## Sign Permit, 98 Washington Ave.

Flying Fox JUICE BAR
98 WASHINGTON AVE.

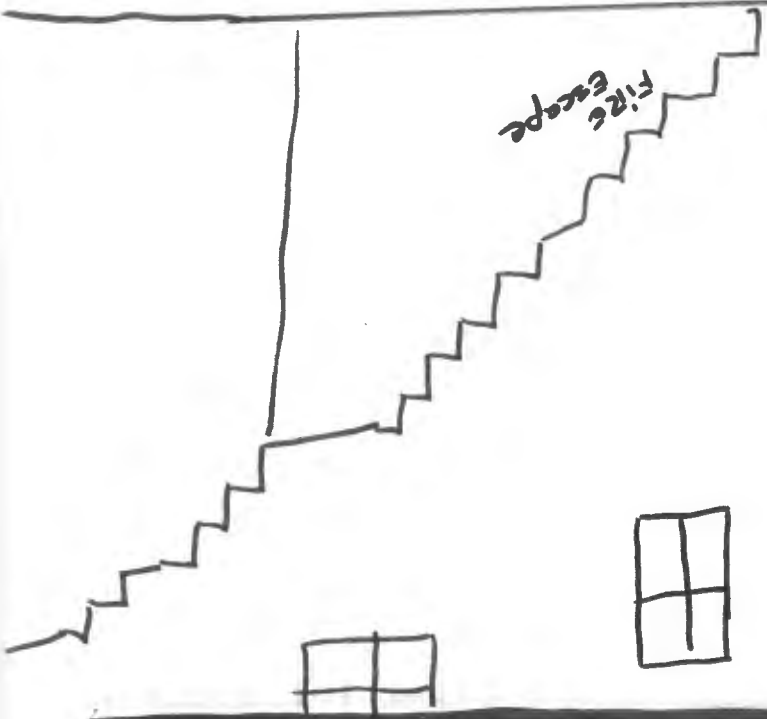
I am reviewing your sign permit application but have encountered one issue with the proposal. In the zone this building is located in, the B-2b zone, the sign ordinance allows only one sign per street frontage. The signs on the Washington Ave. and Madison St. sides are fine, but the third sign that faces the driveway cannot be approved under the ordinance. Do you want to revise the proposal to just be for the two street-facing signs?

Thanks for getting back to me. Yes I would like to revise the proposal for just the two signs. Let me know if you need anything from me! Thanks  
Birch
